Item No. **Report of the Head of Planning, Transportation and Regeneration**

Address 61 GADE CLOSE HAYES

Development: Single storey side extension and conversion of garage into habitable accommodation including replacement of garage door with window to provide a granny annexe

LBH Ref Nos: **52072/APP/2021/3398**

DRAWN: DAF	SCALE: 1:100 @ A3	DATE: September 21
DRAWING NO: 21/402/03		REV:

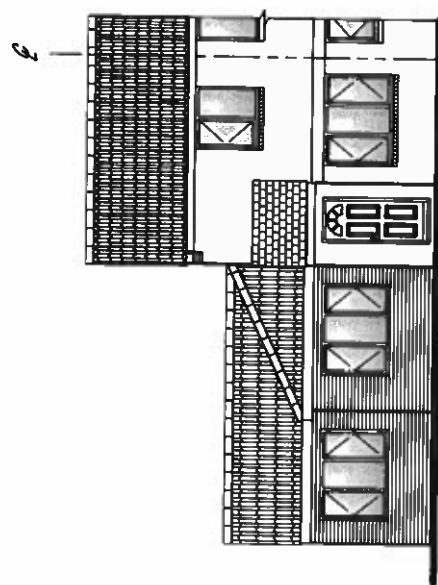
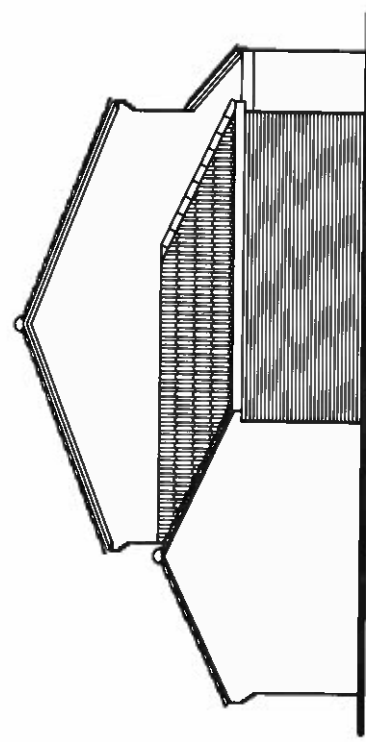
The proposed cumulative impact of the extension and garage conversion is considered unacceptable. Whilst it is noted that the adjoining property at number 63 has been extended to the side, the current proposal fails to comply with spirit of policy DMHD1 which requires side extensions to appear subordinate in scale. The cumulative impact of the extension and garage conversion would detract from the modest character and appearance of this original dwelling. It is noted that the footprint of the proposed annexe at 39 square metres would represent 130% of the footprint of the original dwelling which reinforces the lack of subordination. As such, the proposed single storey side extension, in conjunction with the proposed garage conversion by virtue of its excessive scale, bulk and design, would appear disproportionate to the original dwelling and would fail to harmonise with the architectural composition of the original property and would be detrimental to the character, appearance and visual amenities of the street scene and the wider area. The proposal is therefore contrary to Policy BE1 of the Hillingdon Local Plan: Part One - Strategic Policies (November 2012) and policies DMHB11, DMHB12 and DMHD1 of the Hillingdon Local Plan - Part Two (2020).

The proposed single storey side extension, in conjunction with the proposed garage conversion by virtue of its excessive scale, bulk and design, would appear disproportionate to the original dwelling and would fail to harmonise with the architectural composition of the original property and would be detrimental to the character, appearance and visual amenities of the street scene and the wider area. The proposed use as an annexe would also not be acceptable as the annexe could be easily adapted to a fully self-contained unit. The proposal is therefore contrary to Policy BE1 of the Hillingdon Local Plan: Part One - Strategic Policies (November 2012) and policies DMHB11, DMHB12 and DMHD1 of the Hillingdon Local Plan - Part Two (2020).

Proposed Ground Floor

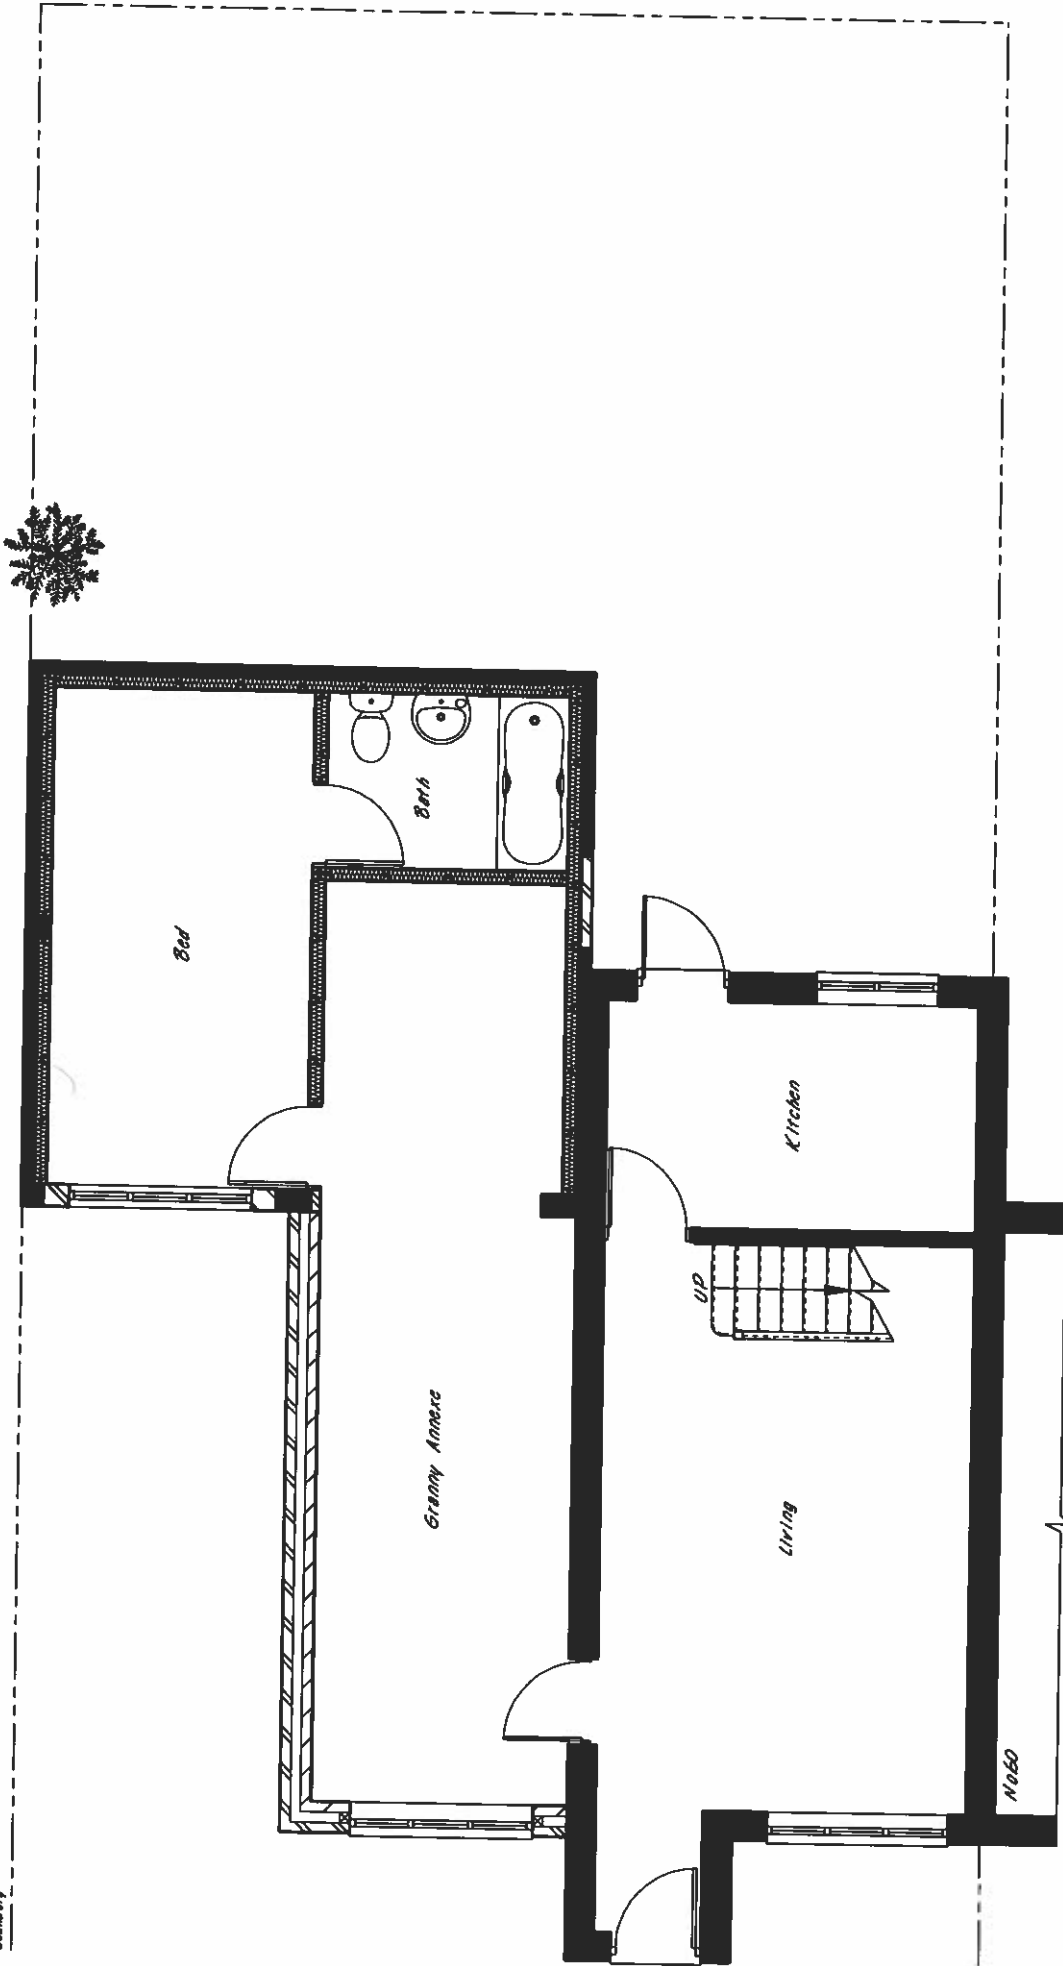
In terms of the proposed use as an annexe, No information has been provided as to the need for the annex, and no Access Statement has been submitted. The annex could also be easily adapted to a fully self-contained unit with the addition of a separate entrance on the side elevation, and the large room labelled 'Granny Annexe' being used to accommodate a kitchen and living room area. This is contrary to Householder Development Policy A1.17 / DMHD 1. The proposed use should be functionally integrated more fully with the main dwelling.
